Subject: FW: Planning Application 3 / 2024 / 0096

Re Planning Application 3 / 2024 / 0096

Access Detail (Scale 1:200)

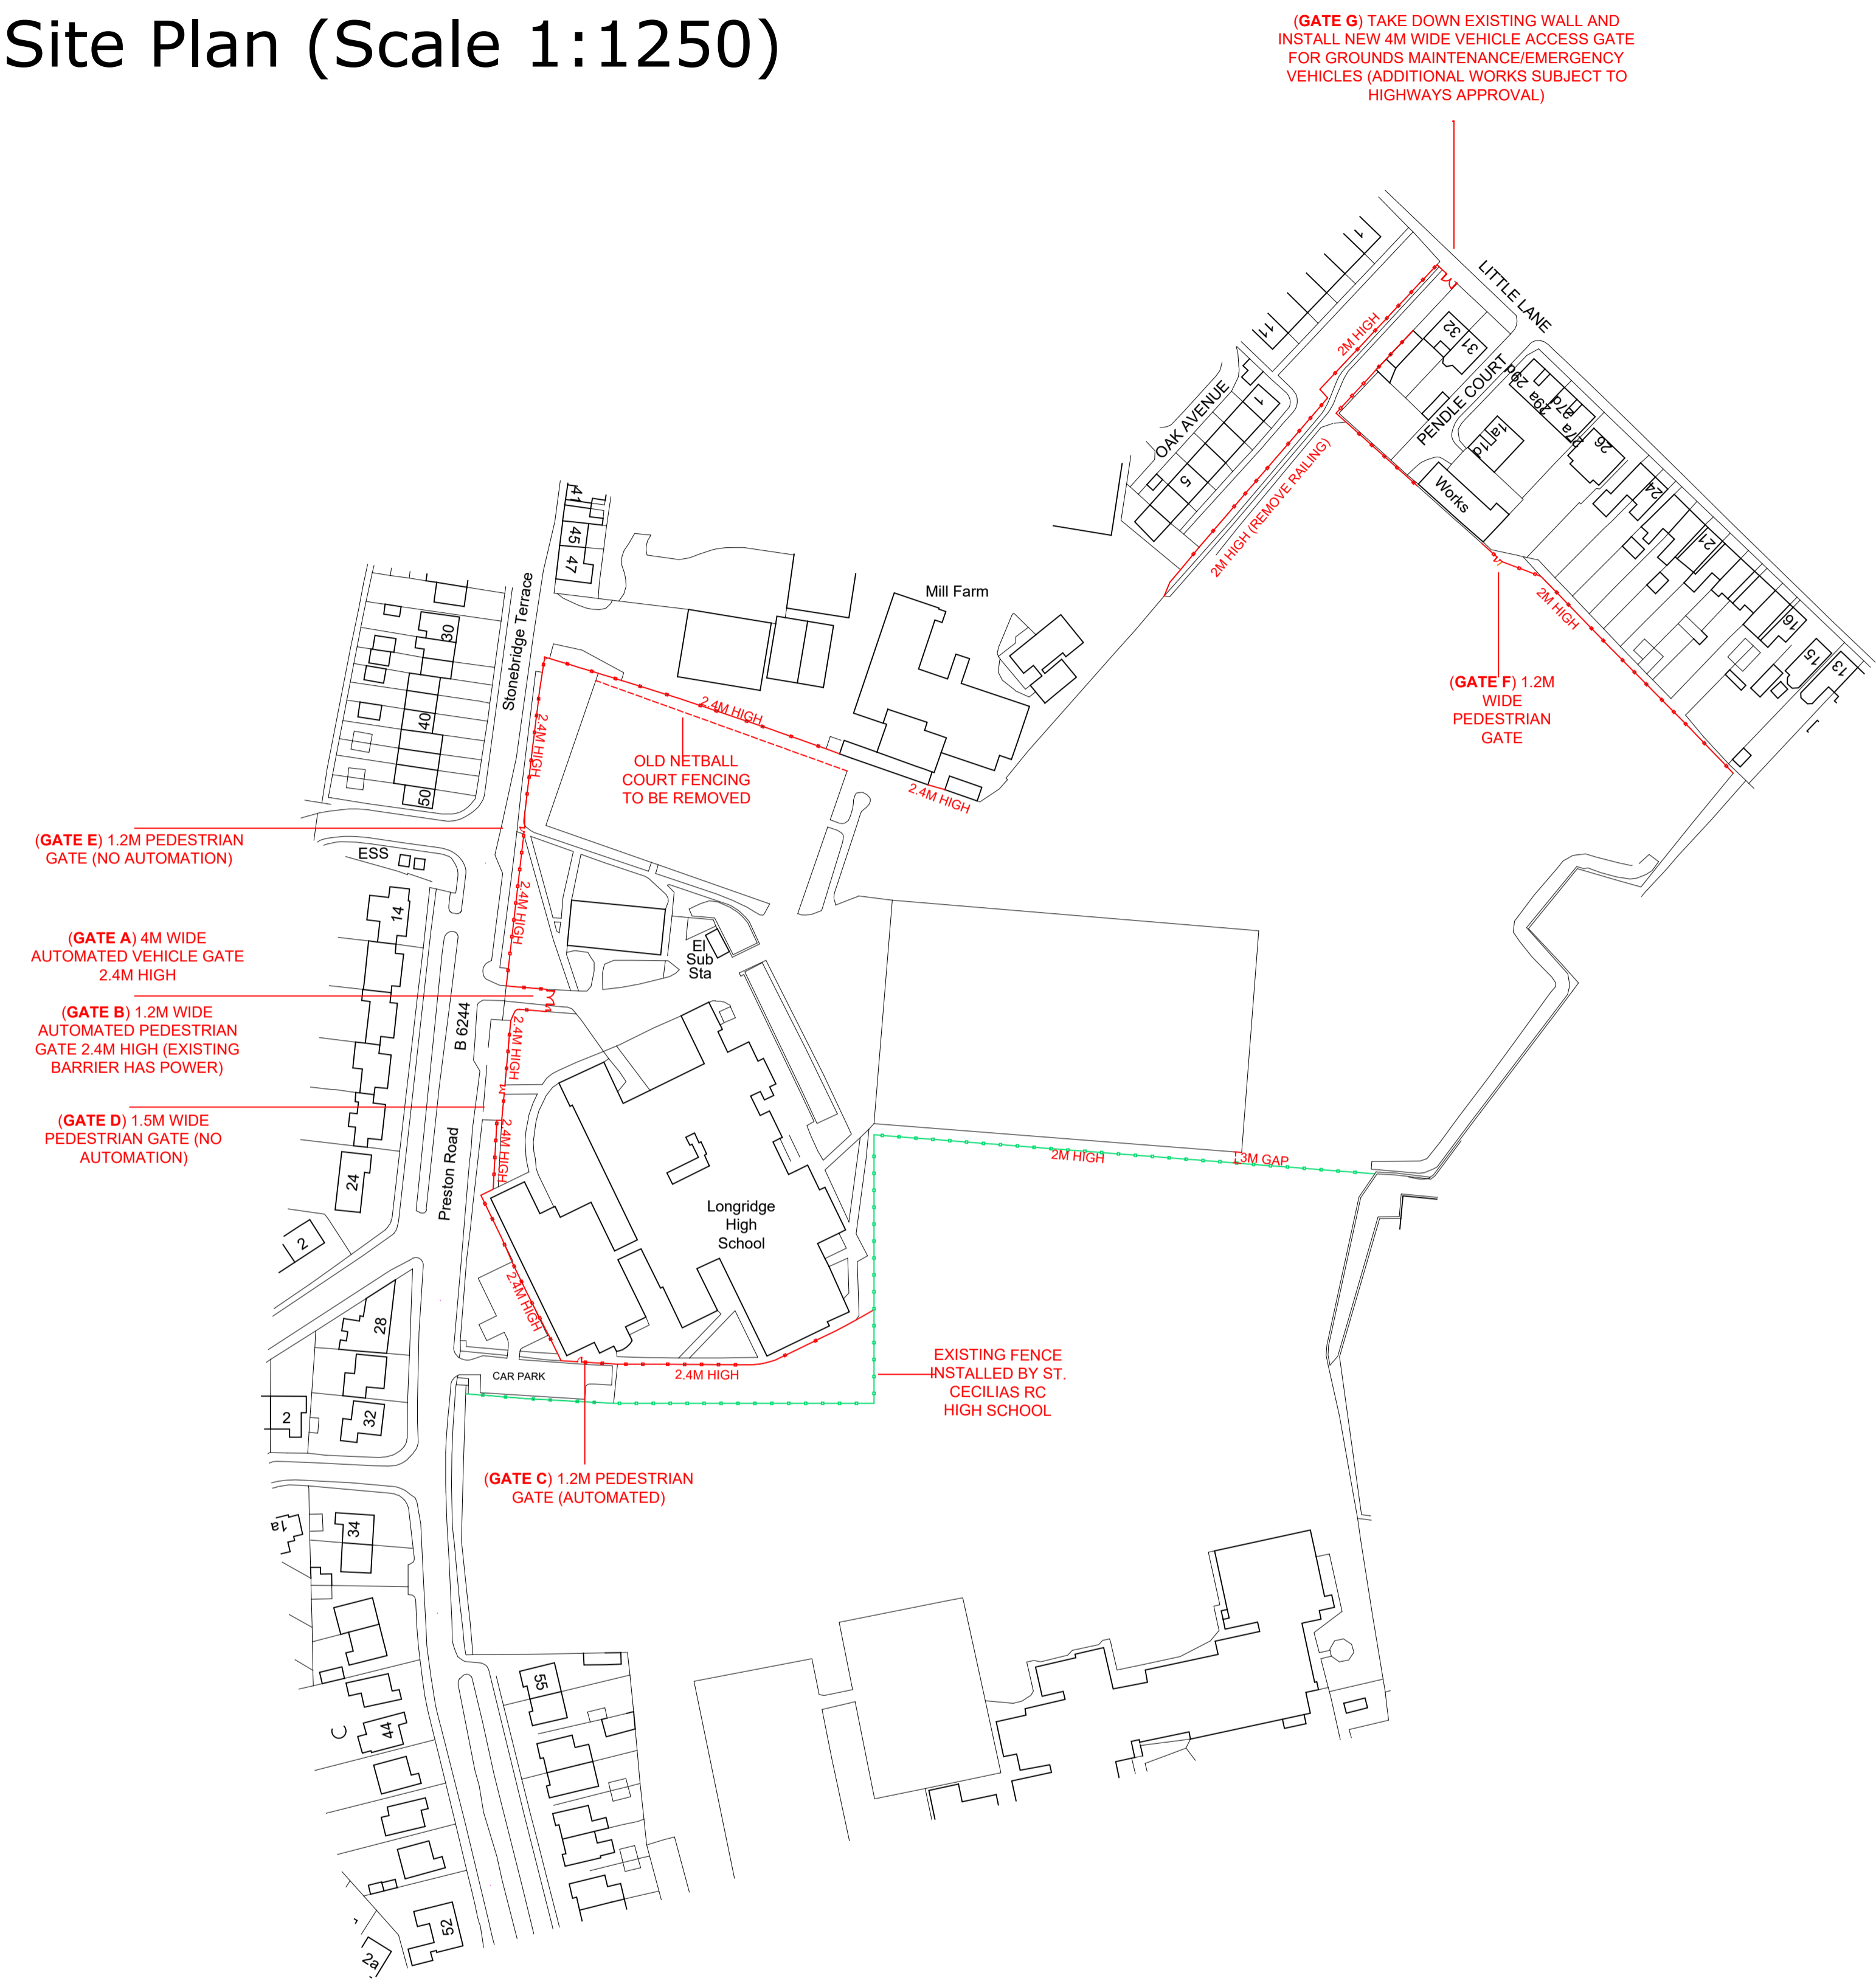
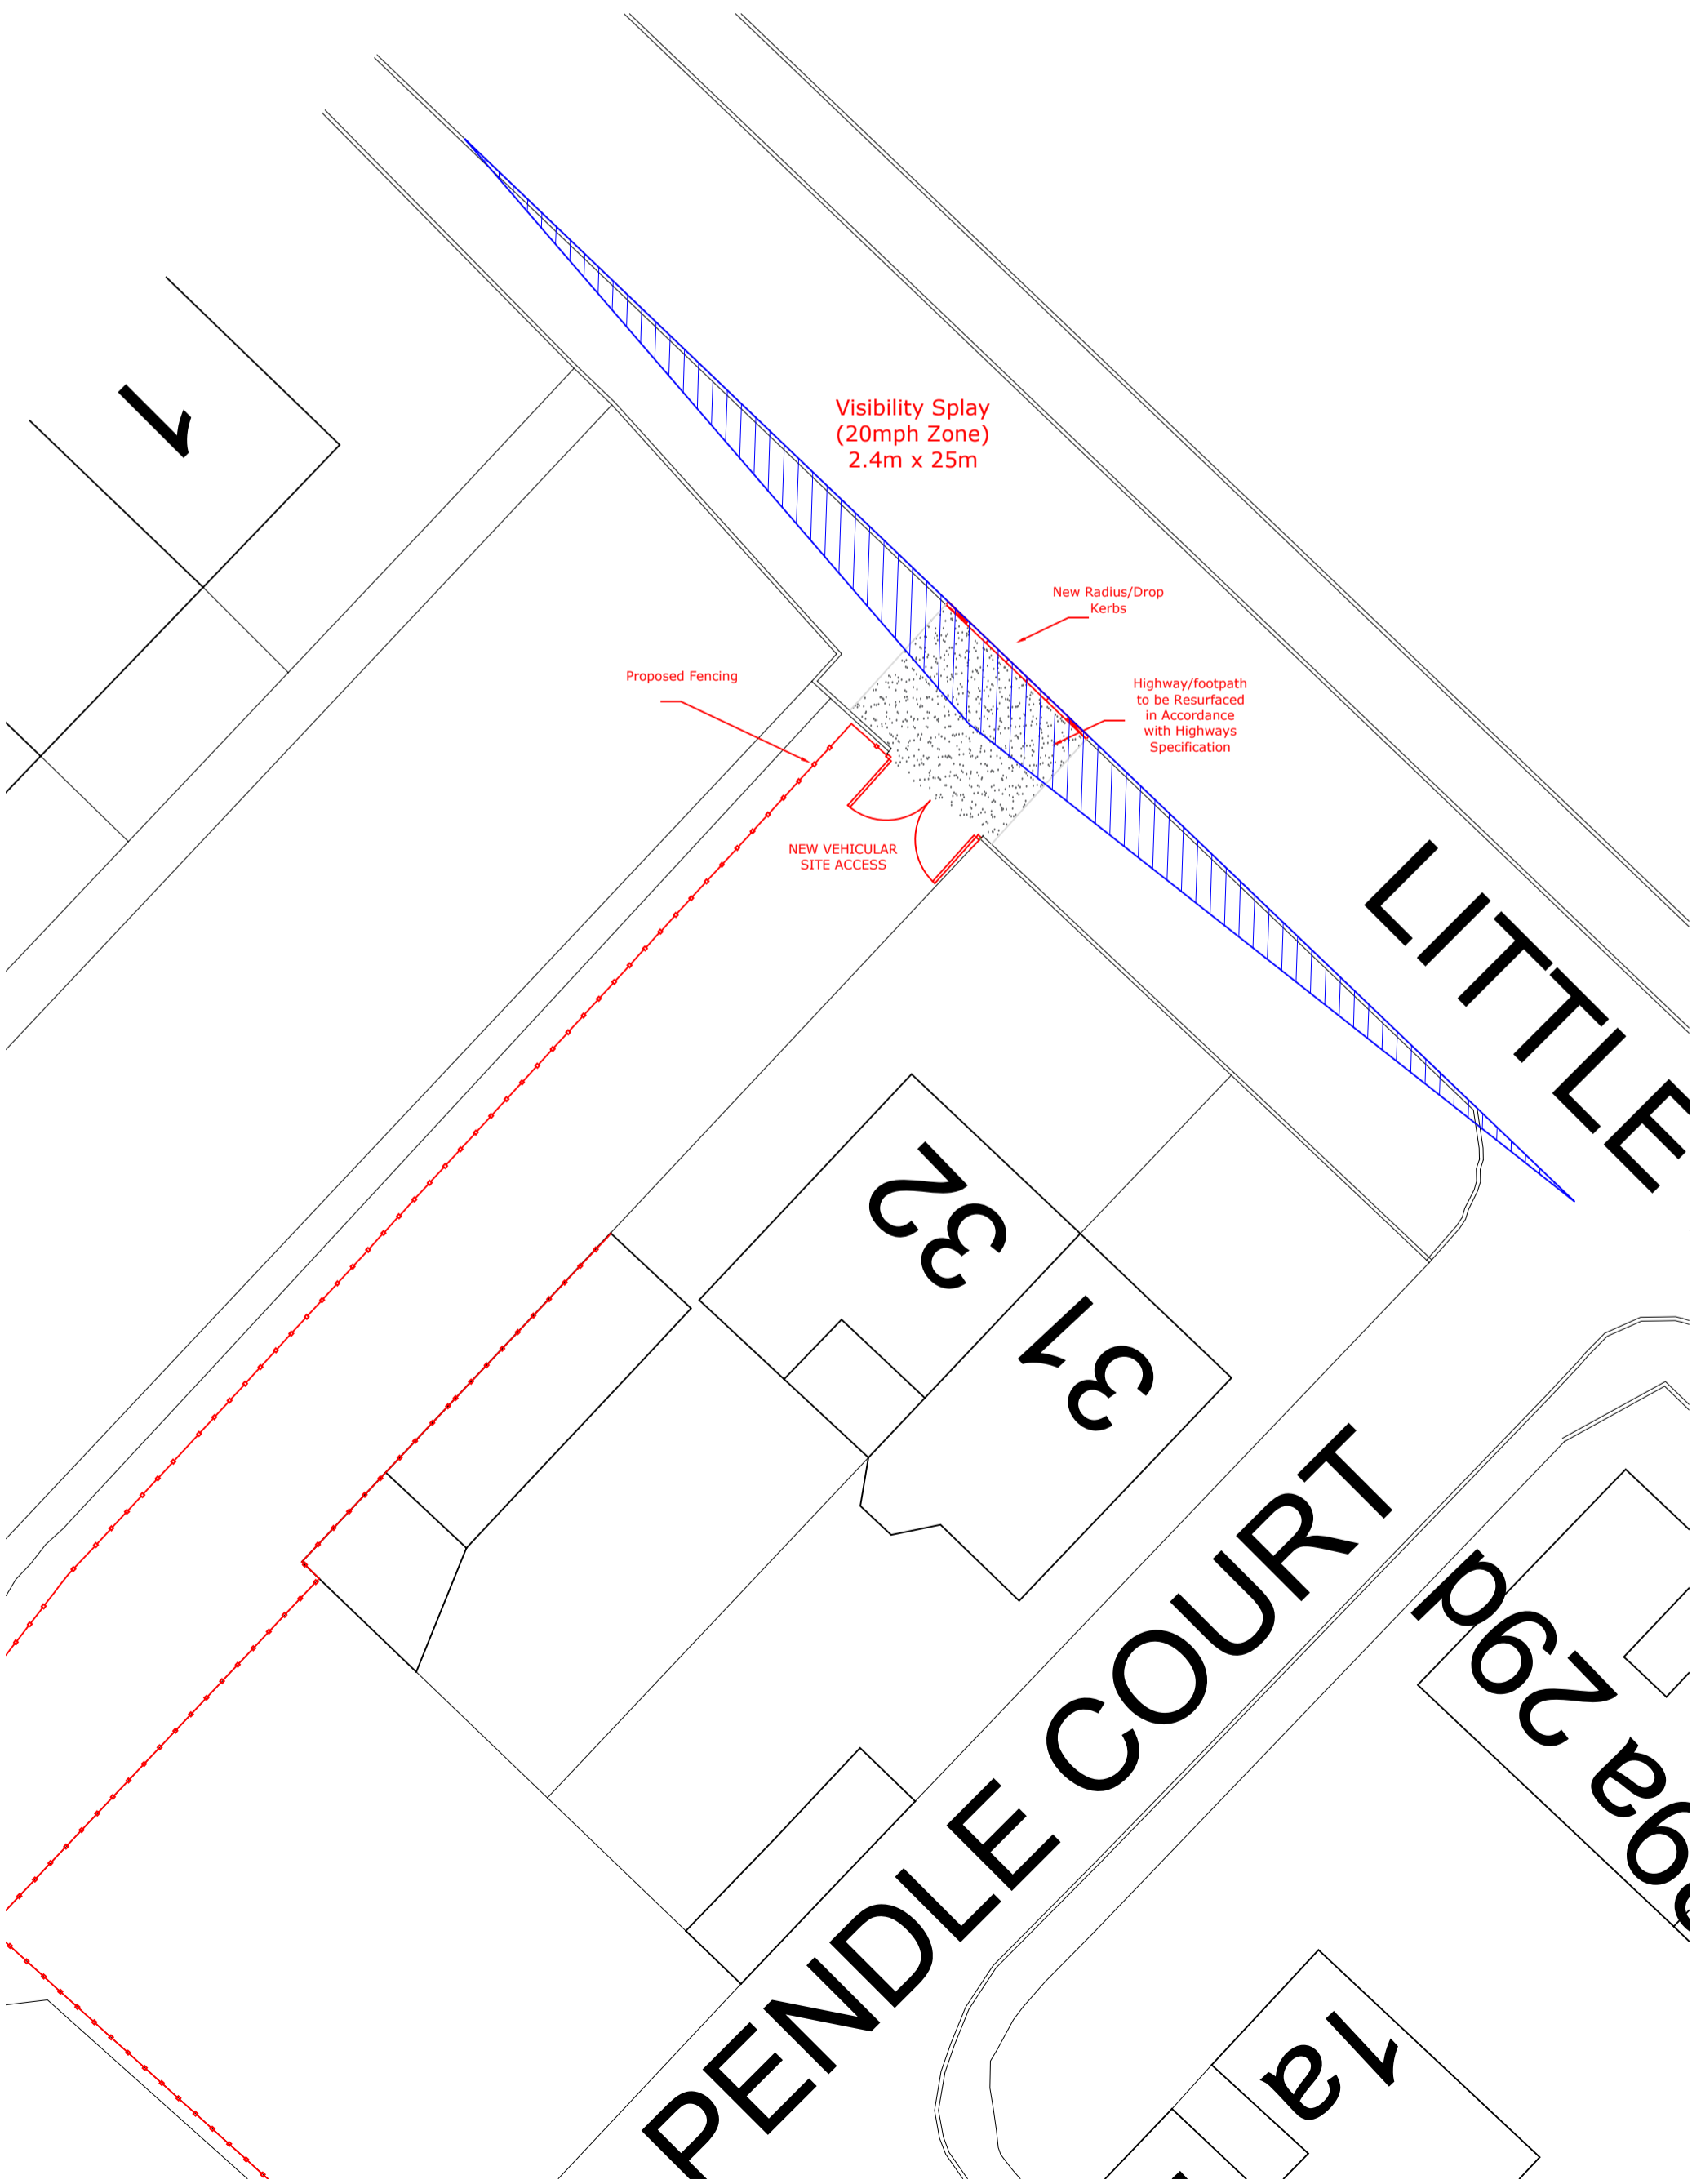
I note the intention to use Pendle Court (see photo 1) as access to Longridge High School grounds.

I wish to raise a cautionary point, which ought to be brought to the attention of LCC, and all external contractors in relation to installation of an access road.

I urge planners, landscape architects, and building contractors to check the direction of the culvert, and to ensure the culverting is not disrupted, or (much worse) blocked during construction processes.

Blocking Kestor Brook would cause the water table to rise. The change might be gradual, but it would eventually begin to affect property.
